October 23, 2025

DHO Chair
City of Albuquerque
Planning Department
600 2nd Street NW
Albuquerque, NM 87103

Re: Artiste Subdivision, Tract 1-A of Artiste - Preliminary Plat Submittal – **DPM Waiver Request**

PRELIMINARY PLAT  
ARTISTE SUBDIVISION  
PHASE 1

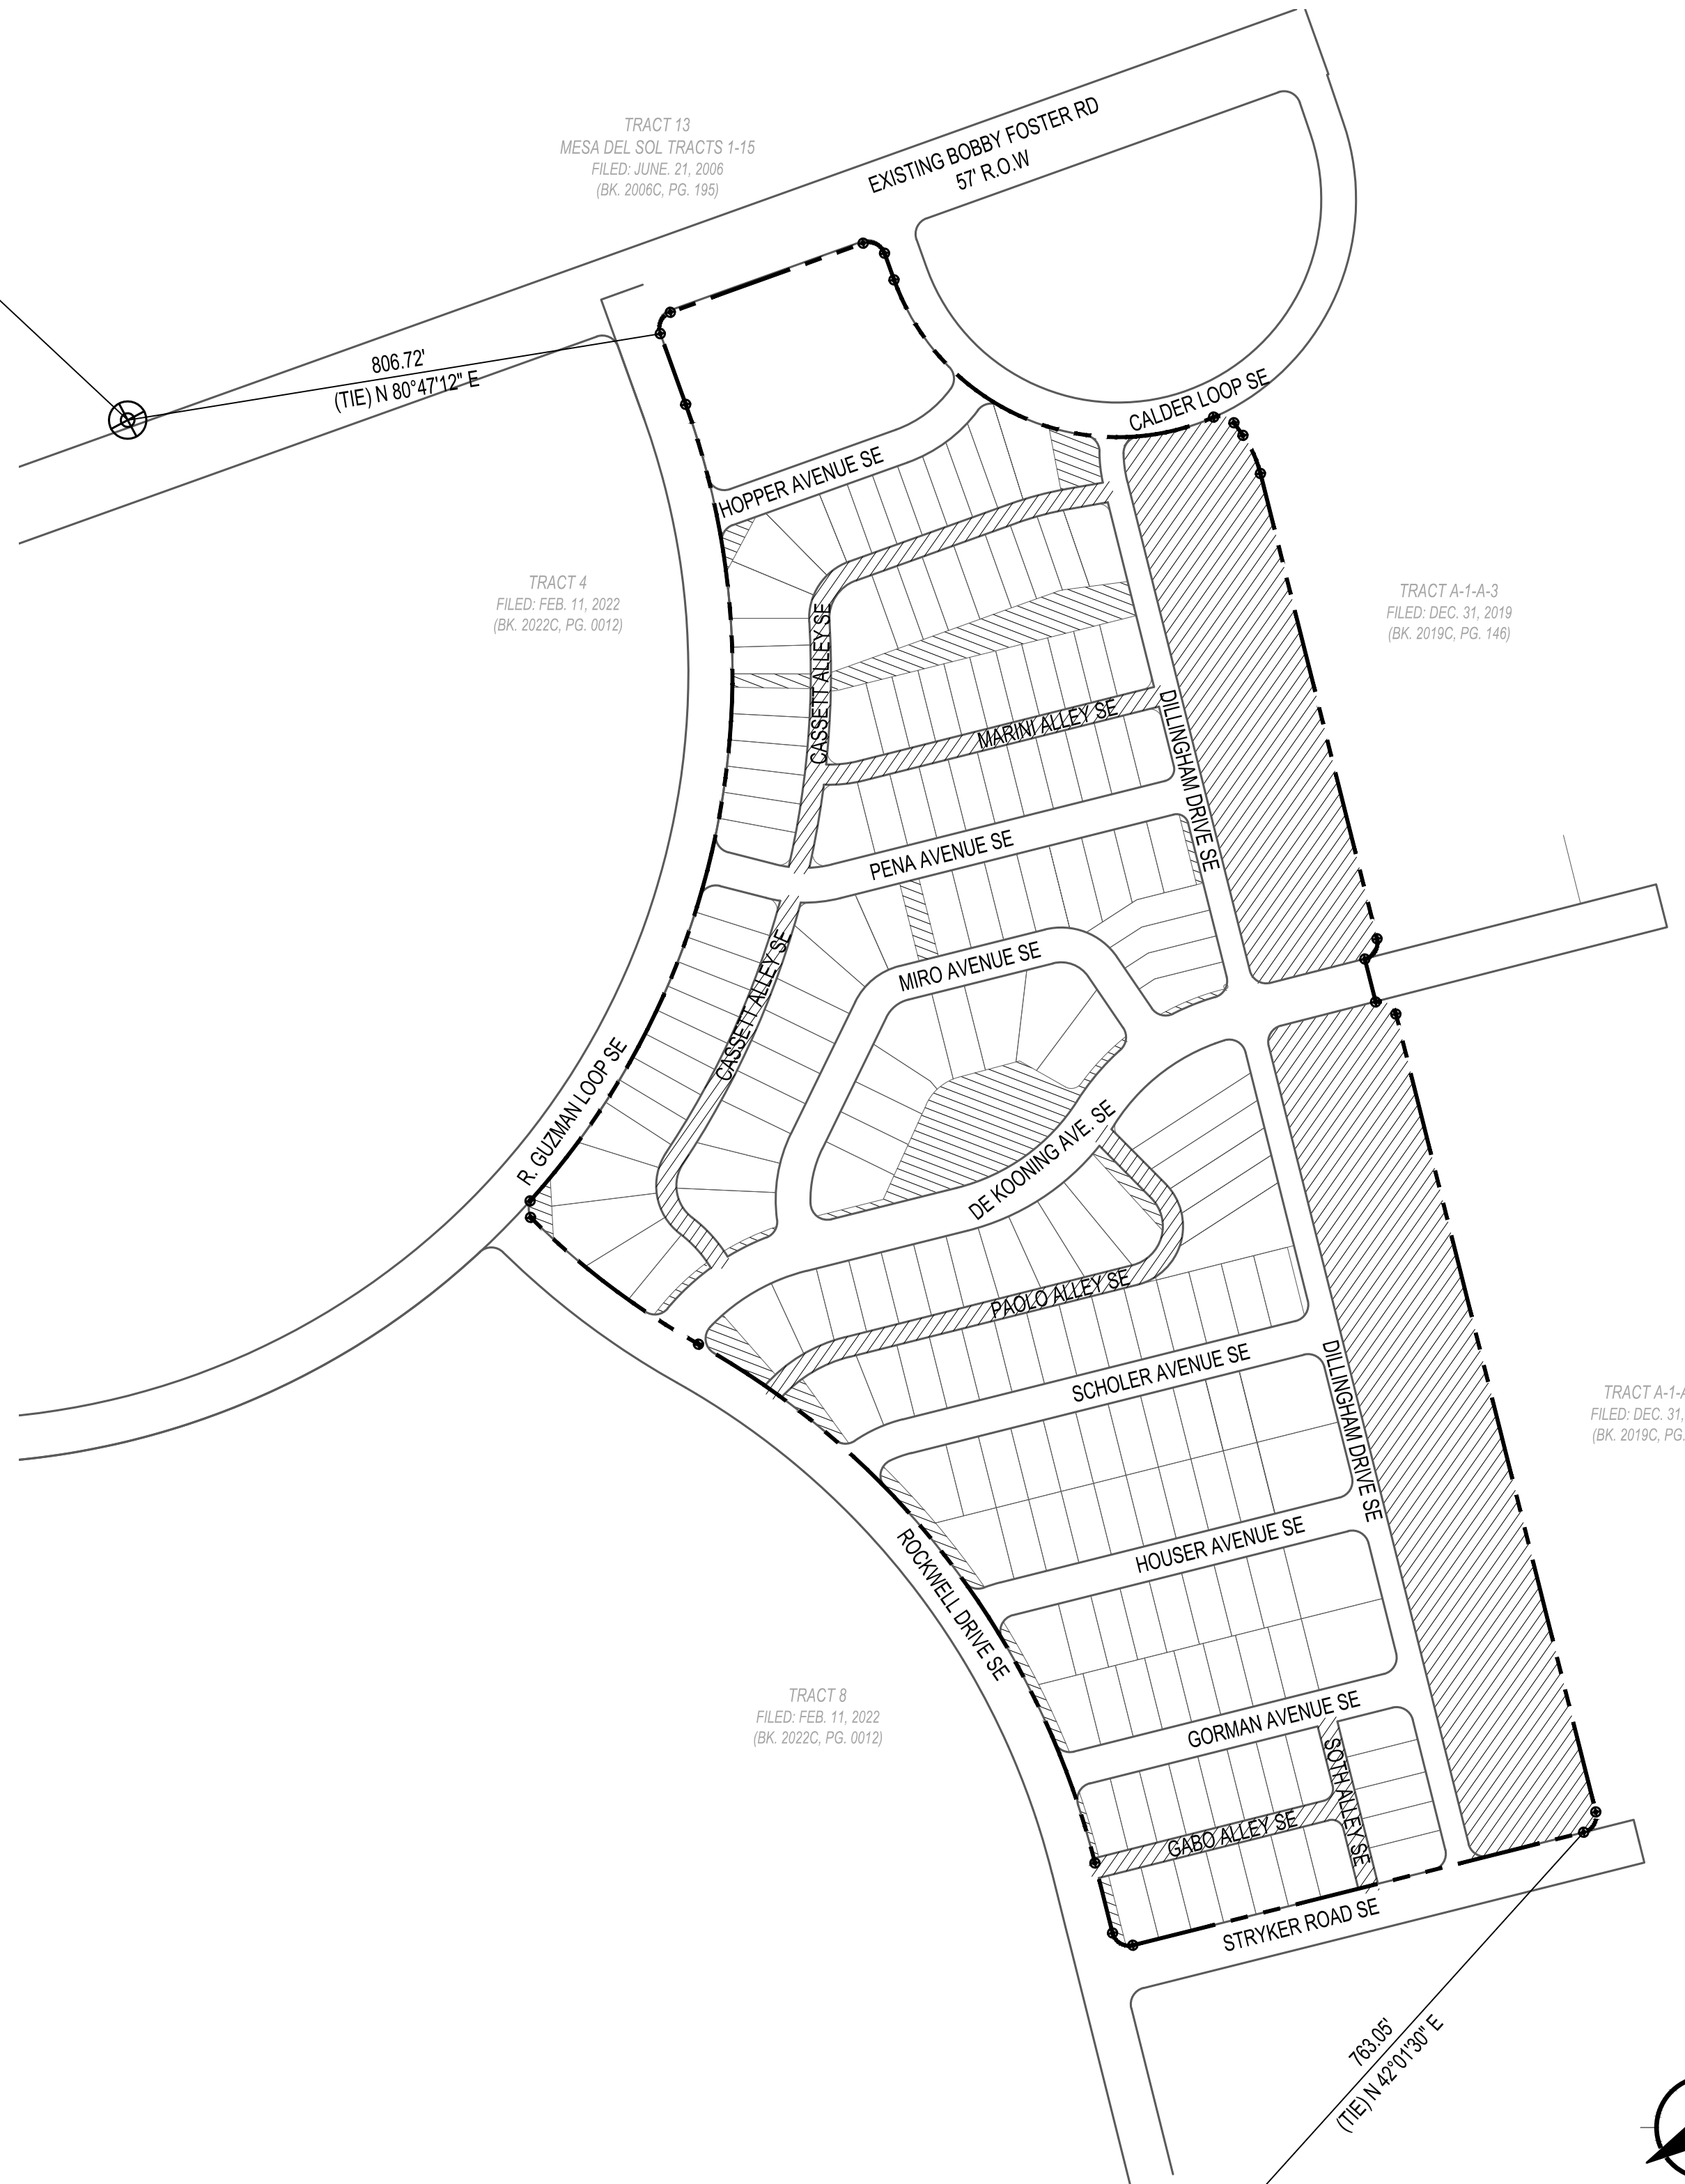
Standard Centerline Radius for a Local Access Street 7-4(1)(2)

- The DPM indicates that “local residential streets with 90 or near 90-degree turns may be designed with a minimum centerline radius of 75’ with the approval of the Traffic Engineer.”
 - There are five locations where there is a 75’ centerline radius, where the road is 90 or near 90-degree. Two are located on Miro Avenue which is a local residential road. The other four are located on the private alleyways. Two are in Cassett Alley and one is in Paolo Alley. Given that the locations mentioned will have no public thoroughfare, the vehicular speeds will be low, allowing for a tighter turning radius.
